CITY OF MERCER ISLAND

RE: SUB19-003, CAO19-005, SEP19-009 Lady Bug Trust Request for Information #1
Consolidated Land Use Applications for a subdivision of one lot into two lots, extinguish and create new easements, steep slope alteration, and a proposed driveway, retaining wall and two homes located within the shorelands.

The City of Mercer Island Development Services Group has performed a review for compliance with the zoning code, Title 19 of the Mercer Island City Code (MICC) for the above land use applications. The following issues need to be addressed before we continue processing of the application. Please refer to the review comments below:

LDYB0000001
Sheet
3 OF 4

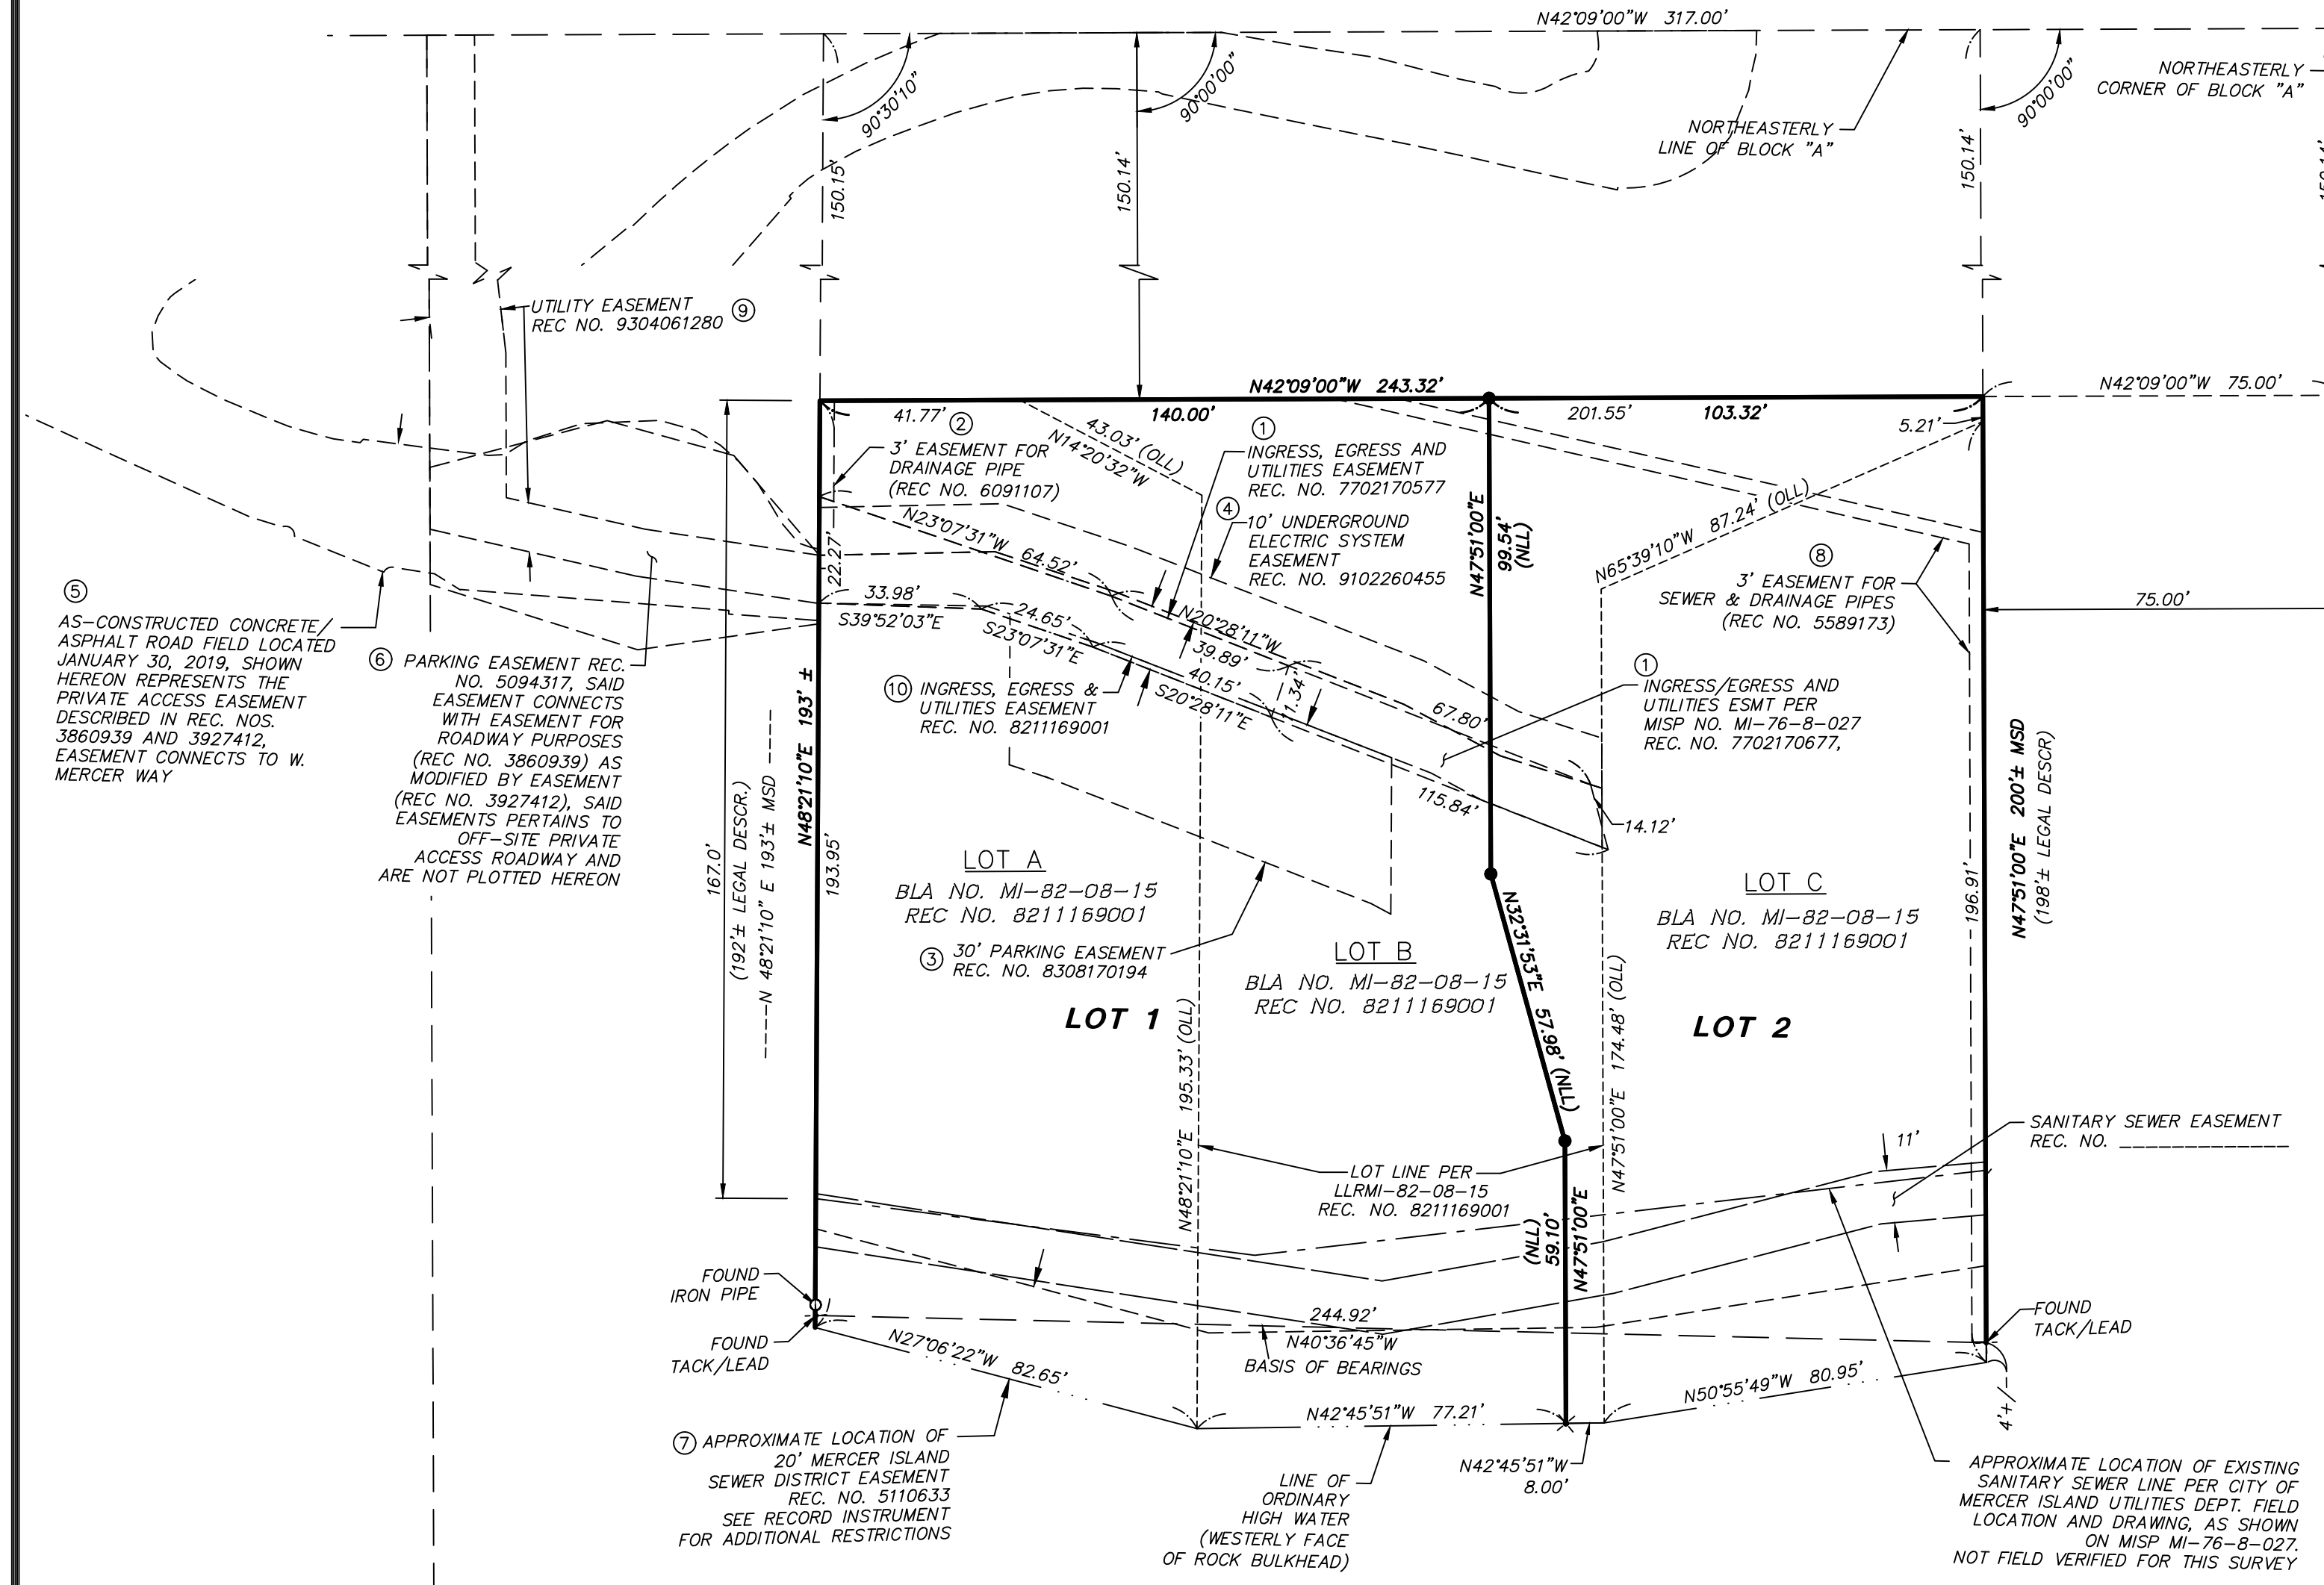
3. When resubmitting the plan set, please add “clouding” around all of the changes from the first to the second submittal.
4. Please provide a project narrative for all the applications: SUB19-003, CAO19-005, SEP19-009. SUB19-003 is a Short Plat and Short Plat Alteration application (both in one application). **SUB19-003 is technically not a Short Plat Alteration application, however the applicant still needs to make it clearer what is happening with the existing easements (ingress/egress and utilities) and the proposed easements.**

6. Please note that no structures are allowed within easements, including retaining walls; unless there is a recorded agreement. Refer to MICC 19.02.020(F).
7. Please keep in mind that there is a 5-foot setback for structures from vehicular access easements per MICC 19.02.020(H)(1).

29. Please show the exact locations of the sewer gravity line and the sewer pressure line (it has been field located), then show a revised public sewer easement, 5 feet from the southern sewer line and 5 feet from the northern sewer line. Once the limits of the easement are reviewed, then

TOPOGRAPHIC & BOUNDARY SURVEY

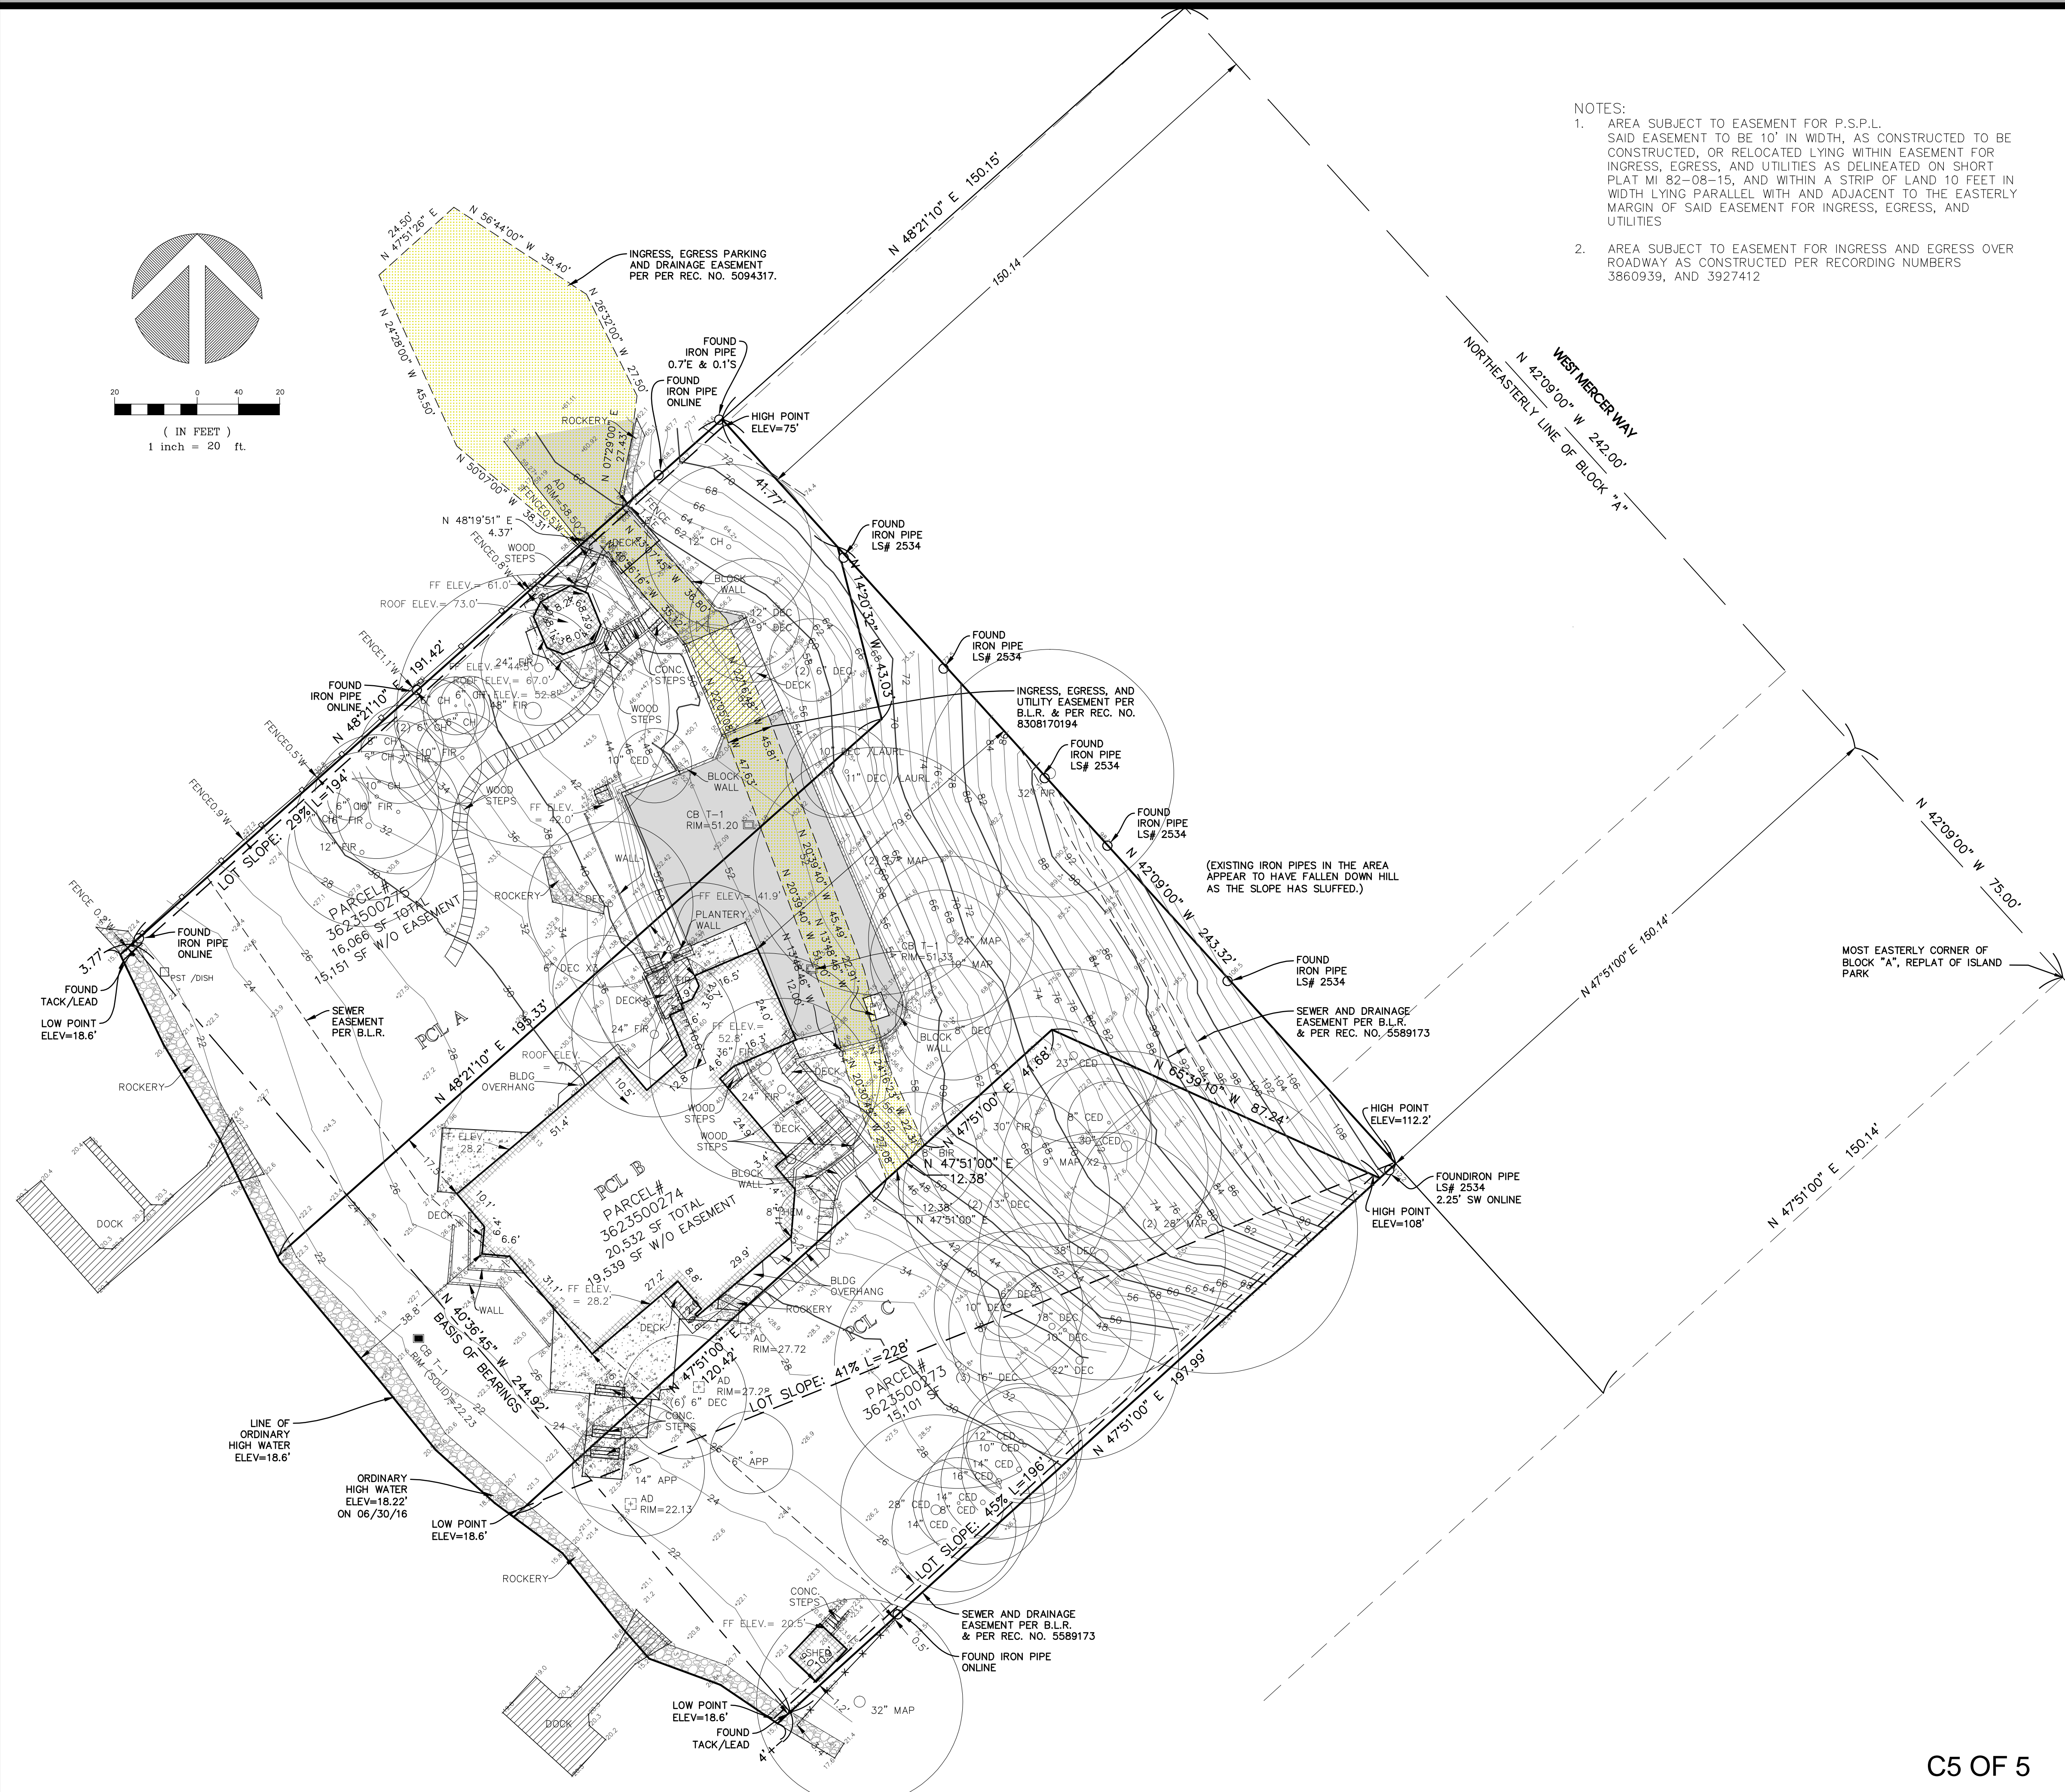
9. Please provide a topographic and boundary survey. The applicant shall provide copies of a topographical map showing the existing land contours using vertical intervals of not more than two feet, completed and signed by a Washington licensed surveyor. For any existing buildings, the map shall show the finished floor elevations of each floor of the building. Critical slopes exceeding 30 percent must be labeled and delineated by a clearly visible hatching. Please keep in mind that the critical slope area is different from the steep slope area, as the City defines steep slope as exceeding 40% slope. ***In addition, see comment #29 for additional information required on a survey.***
